Consultation Response from KC,
Lead Local Flood Authority

2020/91488 Former North Bierley Waste Water Treatment Works, Oakenshaw, BD12 7ET

Reserved matters application pursuant to outline permission 2016/92298 outline application for re-development of former waste water treatment works following demolition of existing structures to provide employment uses (use classes B1(c), B2 and B8)

Date Responded:
24/06/2020

Orig Title: DRAINAGE MASTERPLAN
PHASE 2

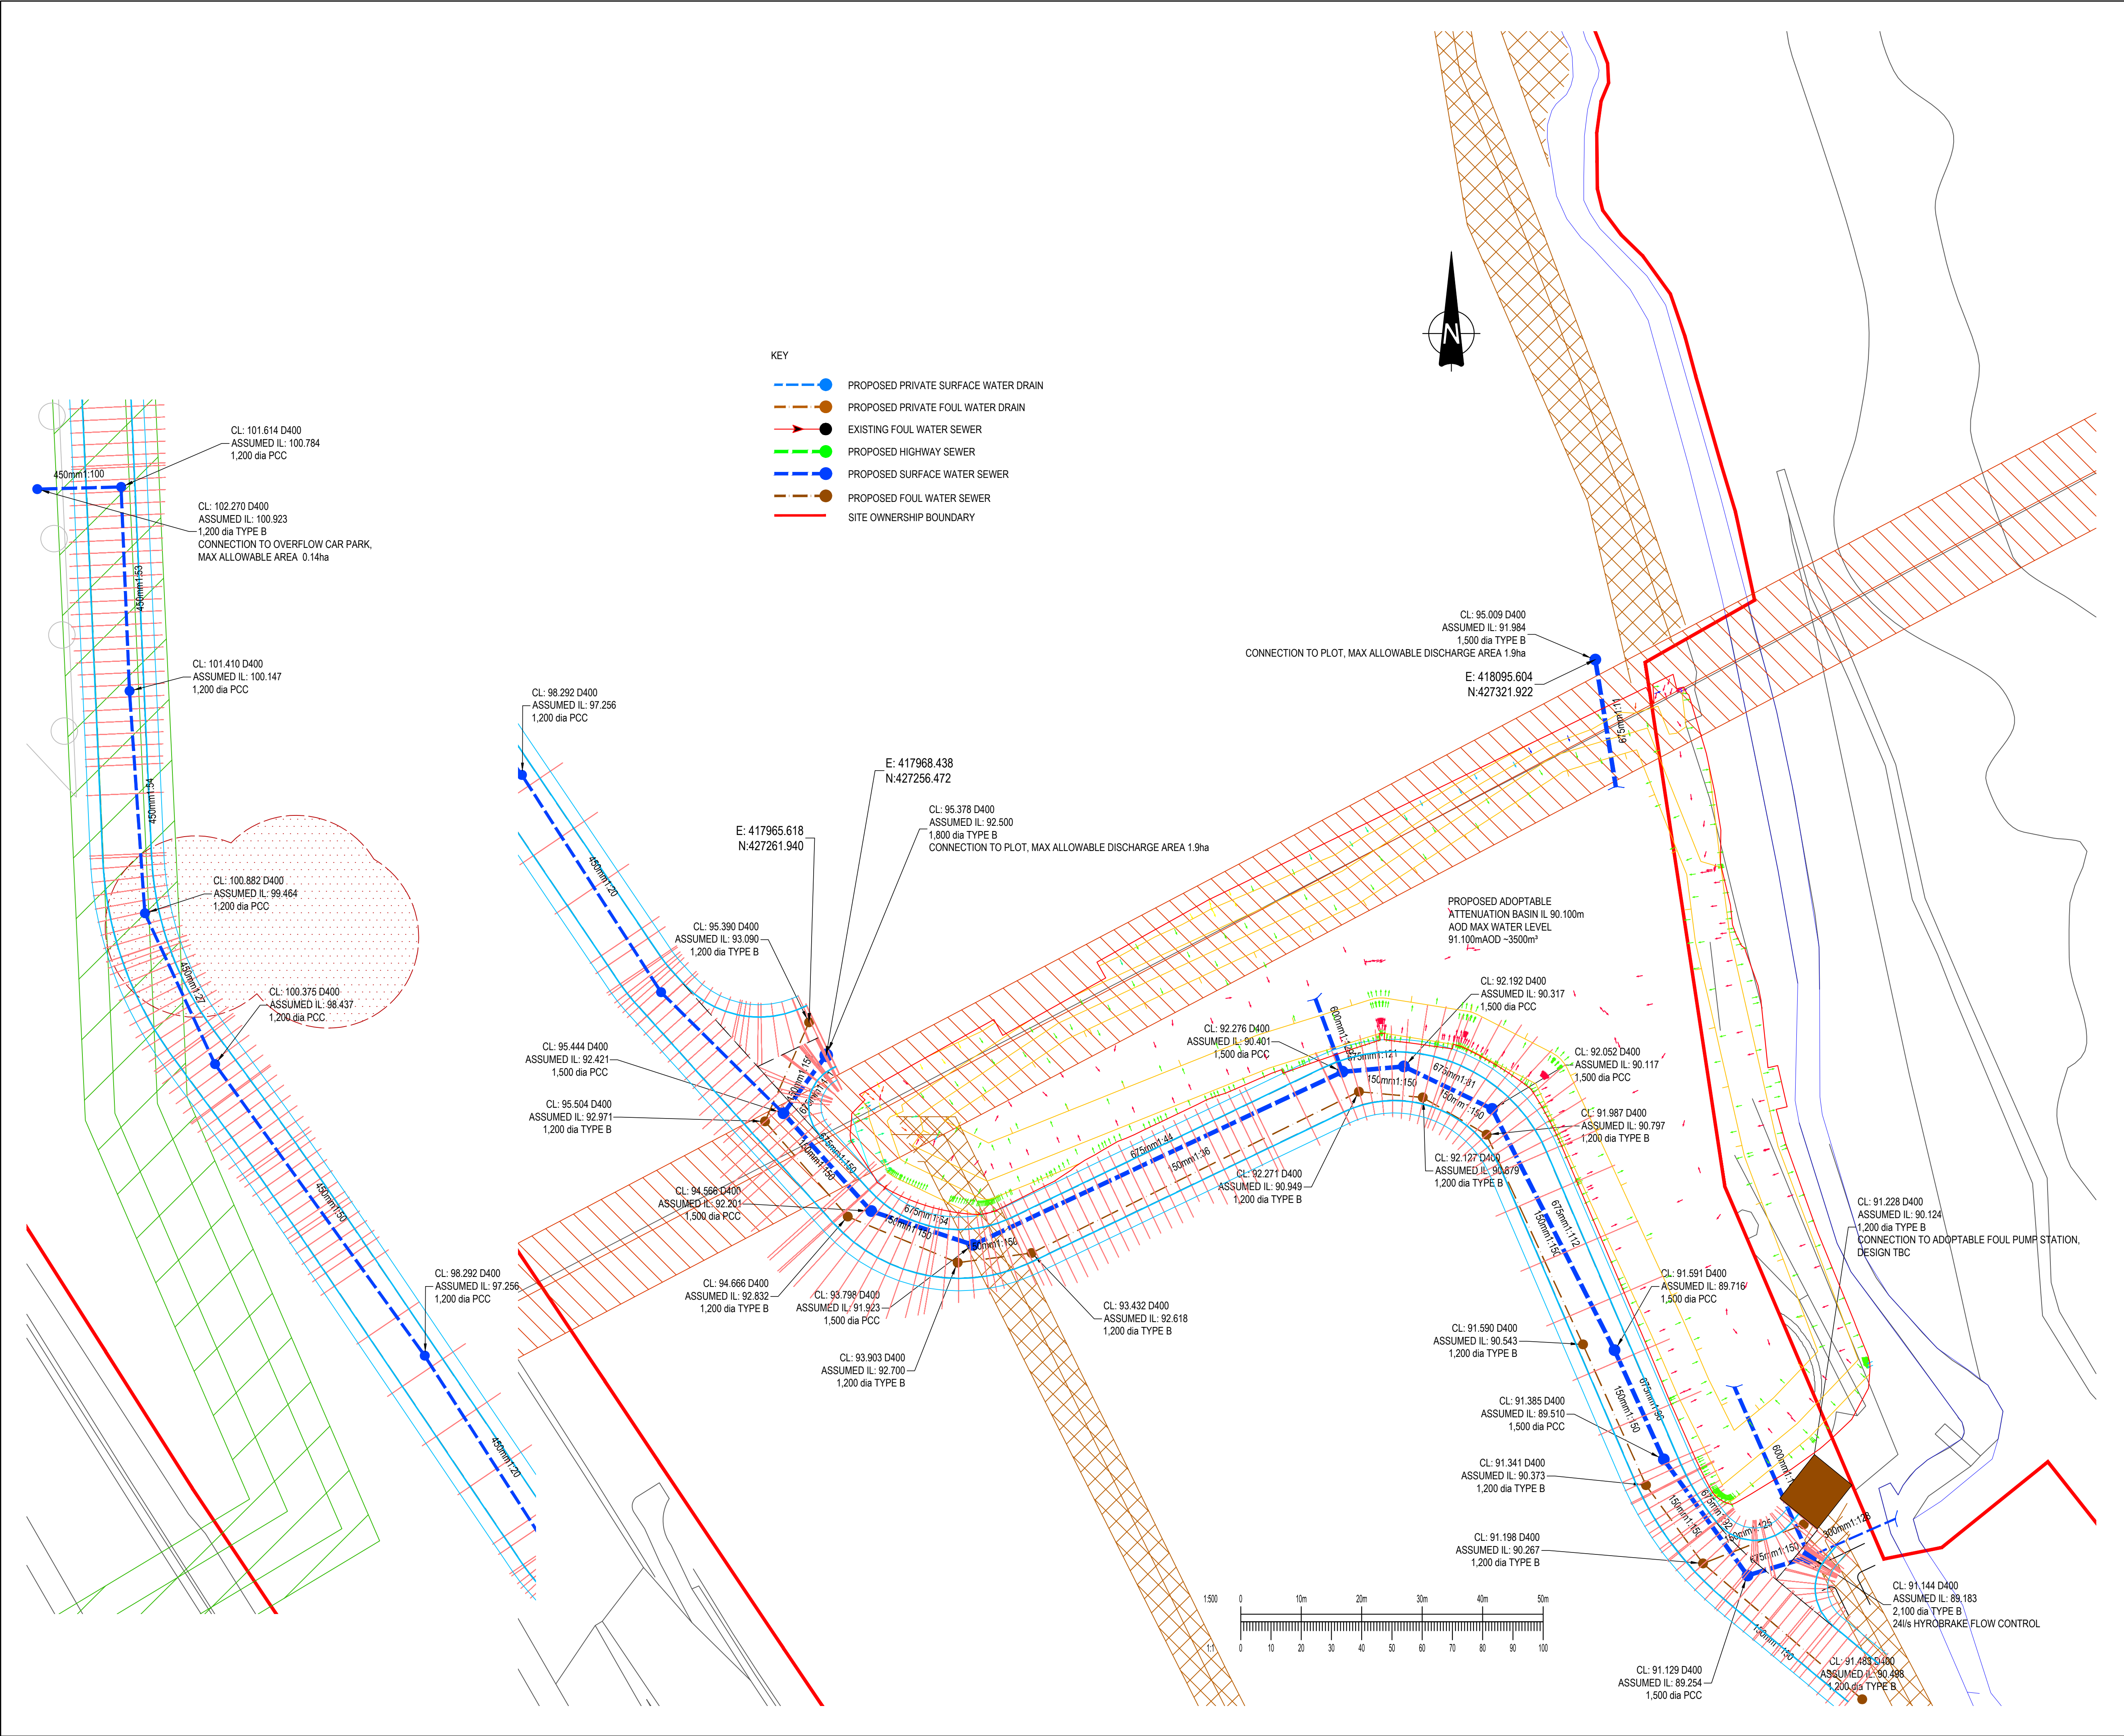
Kirklees LLFA note two attenuation ponds are proposed, the applicant should provide full design details of these elements alongside the wider site drainage when submitting any future Discharge of Conditions application. It is noted that the Section 38 drawings provided do not include these ponds. **Full details of the drainage and ponds must be provided as part of any discharge of condition application. The applicant should confirm if the newly released guidance around adoption of SuDS may mean that the attenuation ponds, which are usually retained in private ownership, will be maintained by Yorkshire Water. This may prompt amendments to the design to meet their adoption requirements.**
